NSW RURAL FIRE SERVICE

Your reference: MP 08_00167 (Mod 2)

12 June 2018

MP 08_0167 (Mod 2) – Belle O'Connor Street, South West Rocks

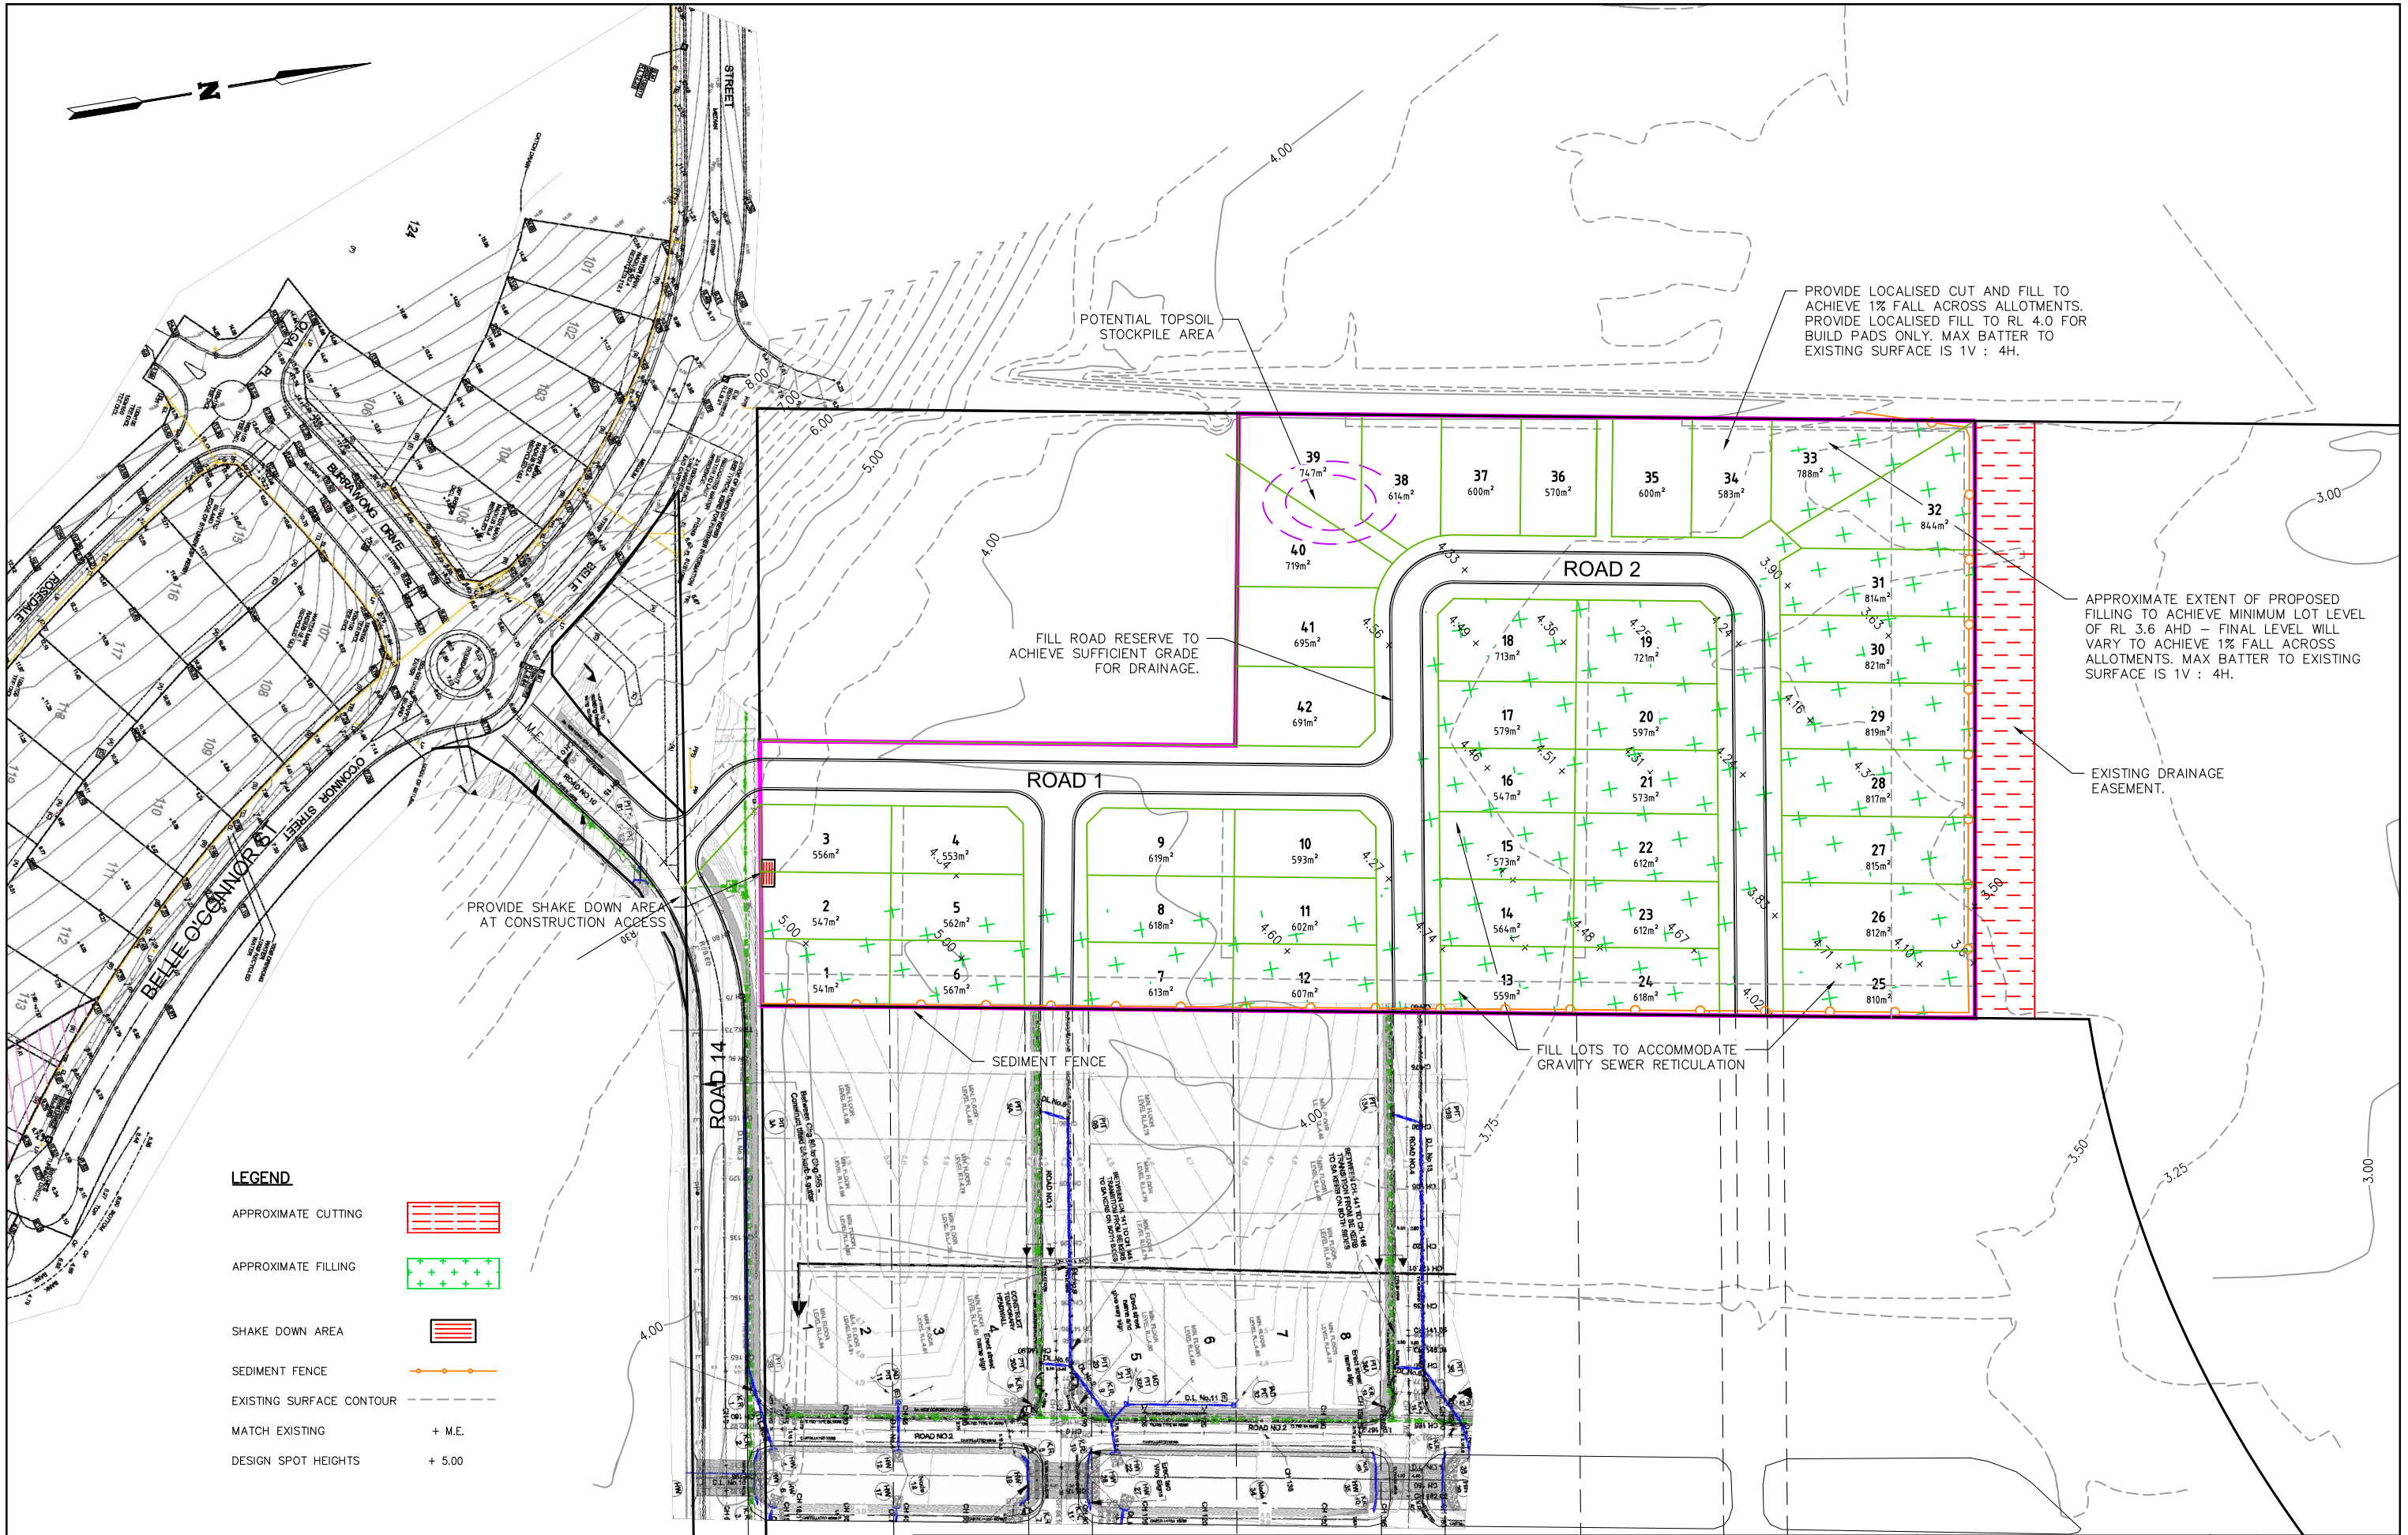
1. The development proposal is to comply with the layout identified on the drawing titled 'General Arrangement & Lot Layout Plan' prepared by de Groot & Benson, reference Project No. 13056, Drawing No. L36-MOD02 (Amendment No. DA2), dated 8 March 2018, except as modified by the following conditions.

2. A minimum 6 metre wide Restriction as to User shall be created over the fire trail to the north of Lots 25 - 33. The Restriction as to User shall require the fire trail to be constructed and maintained in accordance

with section 4.1.3(3) of 'Planning for Bushfire Protection 2006' and the full width of the easement to be managed as an inner protection area (IPA) as outlined within section 4.1.3 and Appendix 5 of 'Planning for Bush Fire Protection 2006' and the NSW Rural Fire Service's document 'Standards for asset protection zones'.

3. The fire trail to the north of Lots 25 - 33 shall include a temporary 12 metre outer radius turning circle at its eastern termination or continue to provide through access to the public road network.

5. A Restriction as to User shall be created over Lots 1, 6, 7, 12, 13, 24 and 25 for the purpose of an 8 metre wide temporary asset protection zone (APZ), as shown on the above referenced plan. The APZ shall be managed as an inner protection area (IPA) as outlined within section 4.1.3 and Appendix 5 of 'Planning for Bush Fire Protection 2006' and the NSW Rural Fire Service's document 'Standards for asset protection zones'. The Restriction as to User for the temporary asset protection zone may be extinguished upon the commencement of development over the affected areas.

6. A Restriction as to User shall be created over Lots 25 to 33 for the purpose of an asset protection zone (APZ), as shown on the above referenced plan. The APZ shall be managed as an inner protection area (IPA) as outlined within section 4.1.3 and Appendix 5 of 'Planning for Bush Fire Protection 2006' and the NSW Rural Fire Service's document 'Standards for asset protection zones'.

Note: the APZ over Lots 25 to 33 may be provided in conjunction with the APZ required over the adjacent fire trail to create an APZ with a total width of not less than 21 metres.
